Deadline 2 Submission – Comments on Written Representations, Local Impact Reports, Applicant Responses, and New Information

Submitted by: Joanna Styles (Interested Party – Kent) Date: 9 December 2025

Sea Link – EN020026

Legend

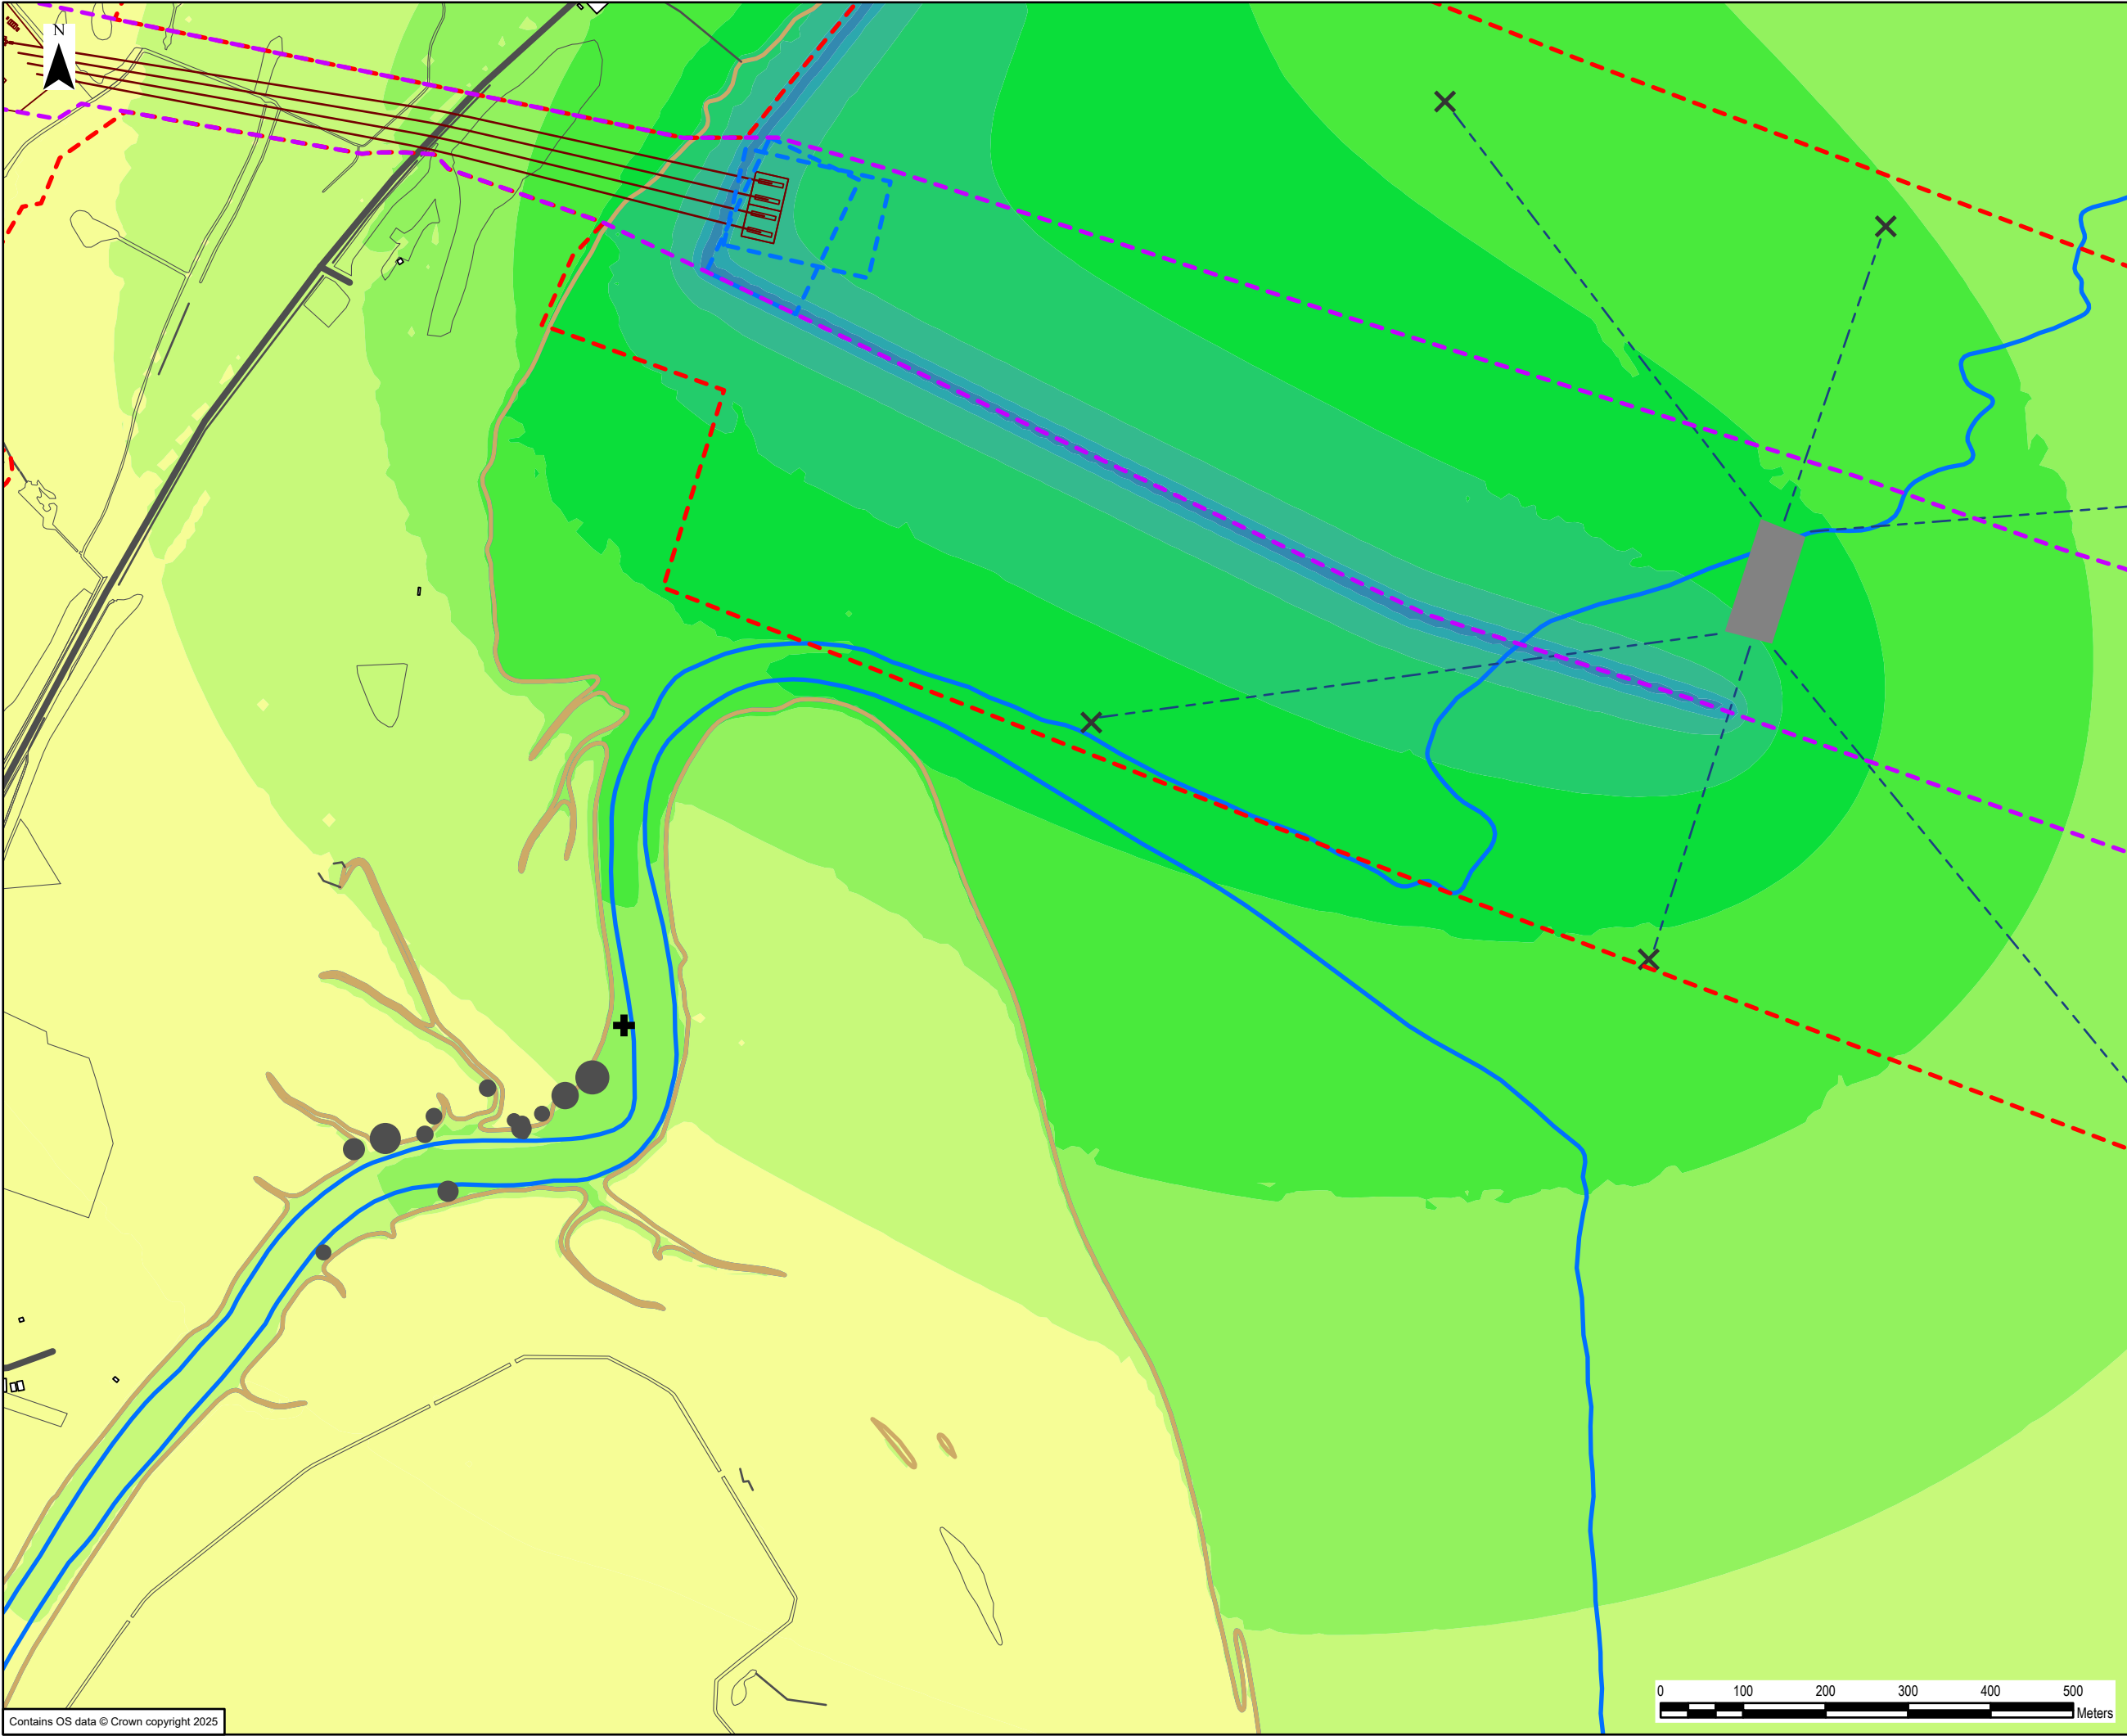
1. The Applicant calculates only TTS/PTS thresholds from airborne noise, not behavioural disturbance.
Behavioural disturbance — *including abandonment of haul-outs* — occurs at far lower levels, and is the primary route by which seals are affected.
2. The model uses M-weighting, which is correct, but the underlying source data remain unchanged from the earlier A-weighted modelling — meaning source uncertainty is not addressed.
3. Reflective surfaces (water, intertidal flats) are treated as “hard” surfaces but no sensitivity analysis is given.
Reflection *increases* effective sound exposure — but this is not explored.
4. The Applicant models only continuous 12-hour use of a vibratory rig + excavators, but does not include:
 - emergency hovercraft deployment
 - unplanned plant movement

2.2.2 Behavioural Disturbance is Not Modelled

Yet the Applicant:

- does not model behavioural thresholds,
- does not quantify changes in haul-out behaviour,
- and fails to consider disturbance to dependent pups.
